From: Paul Cann
Sent: 04 October 2017 11:42
To: Planning.Responses
Subject: RE: Planning Consultation on: BR/229/17/PL

Engineers comments in respect to surface water flood risk:

Site Address: Land to rear of 41 - 47 Pevensey Road Bognor Regis PO21
5NY

Description of Works: Erection of 4 No. dwellings, 1 No. detached garage, parking & alterations to existing access & driveway (resubmission following BR/200/16/PL).

Section AA

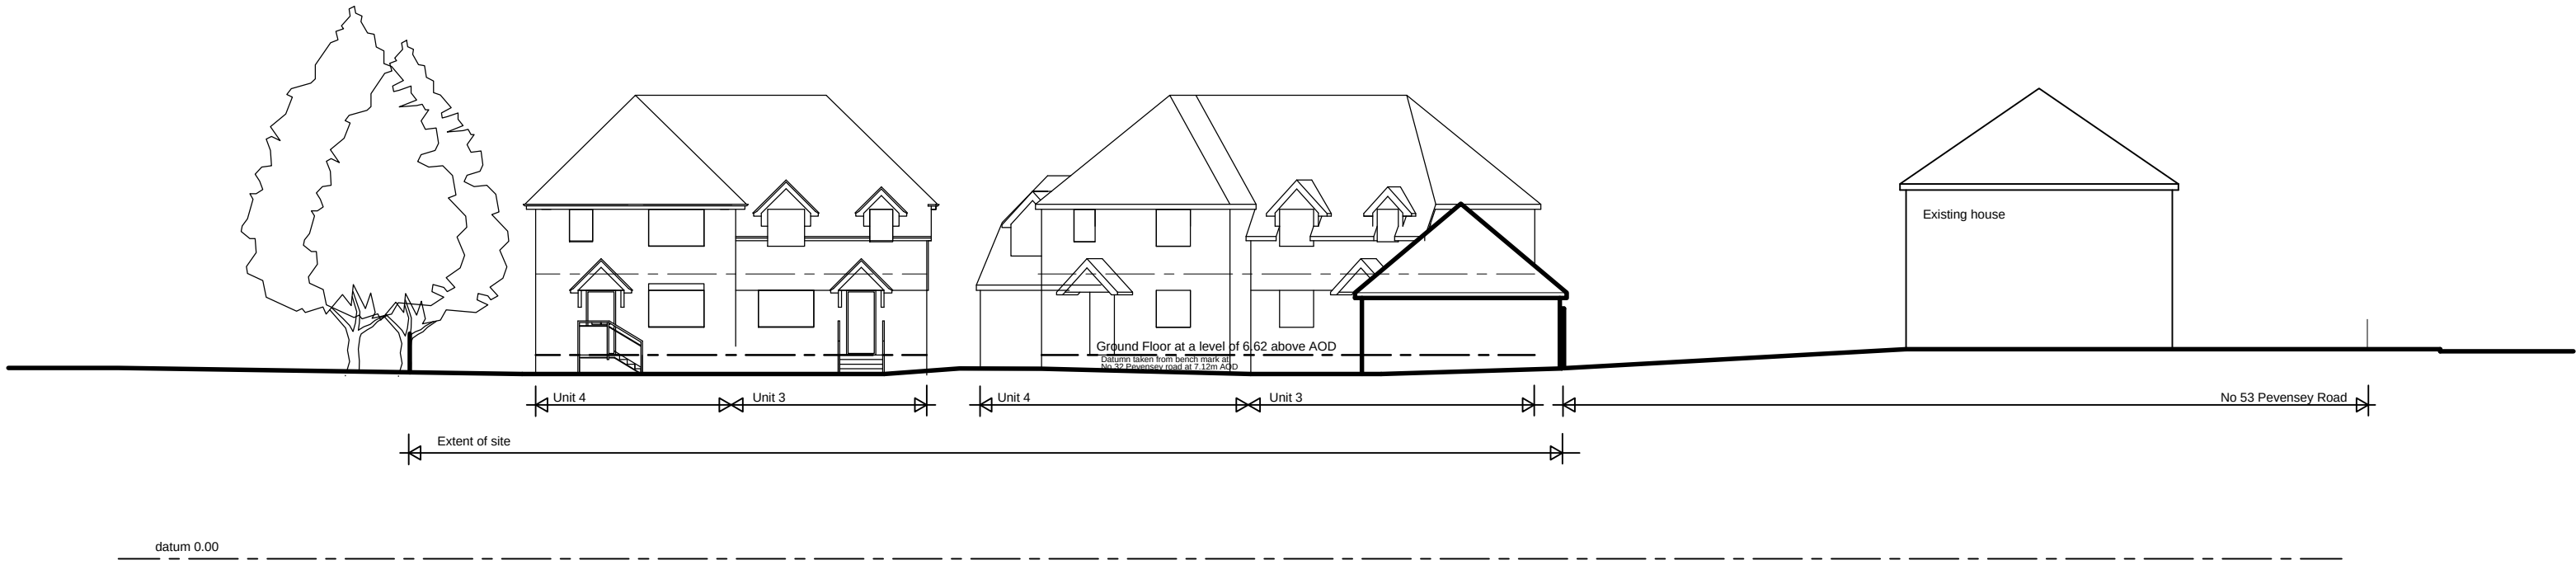
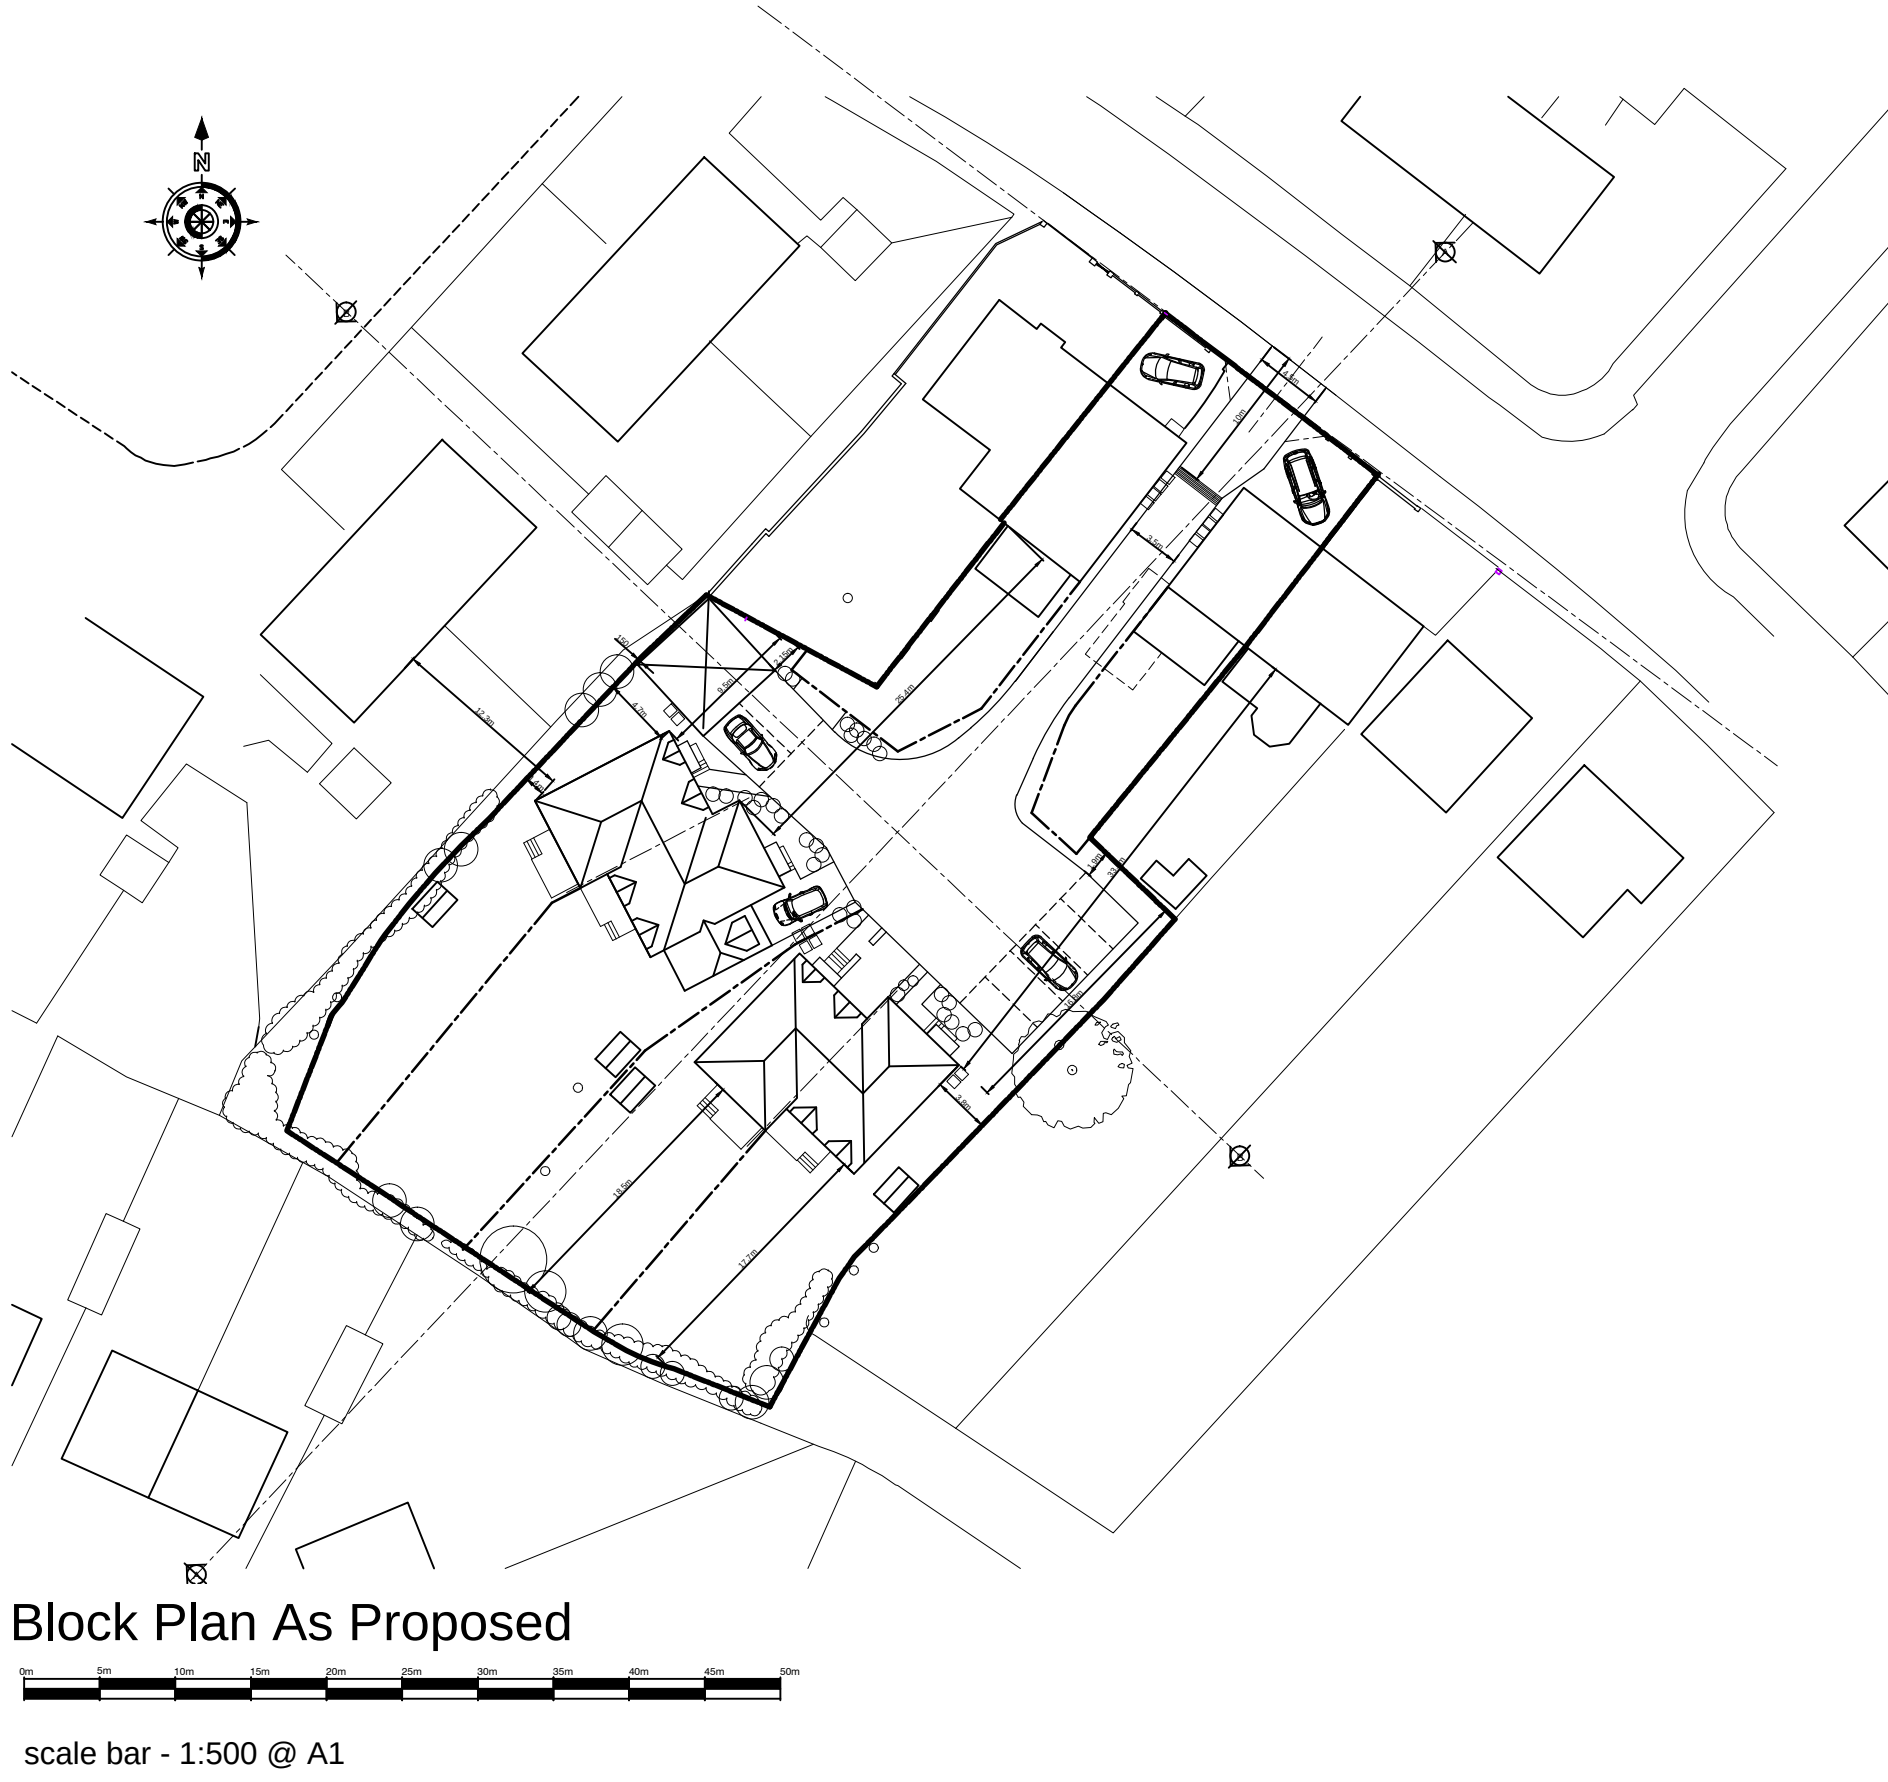
On that basis, I would like to raise an objection to the proposal, until such time that it can be proven that flood risk to neighbouring properties will not be increased. Any raising of ground levels and placing of structures within the flood zone will increase the flood risk. Existing flood storage and flow paths must be maintained (and betterment provided where possible).

A culverted watercourse crosses the site, near to the southern boundary. No new trees to be planted within the vicinity of the pipe and all boundary fences will need to be demountable with fence posts not being positioned above the pipe. The detailed arrangements will need to be agreed. There are remnants of the original ditch that once passed through the site, which represents the lowest area within the site. This must be retained/cleaned out as it provides local drainage/flood storage.
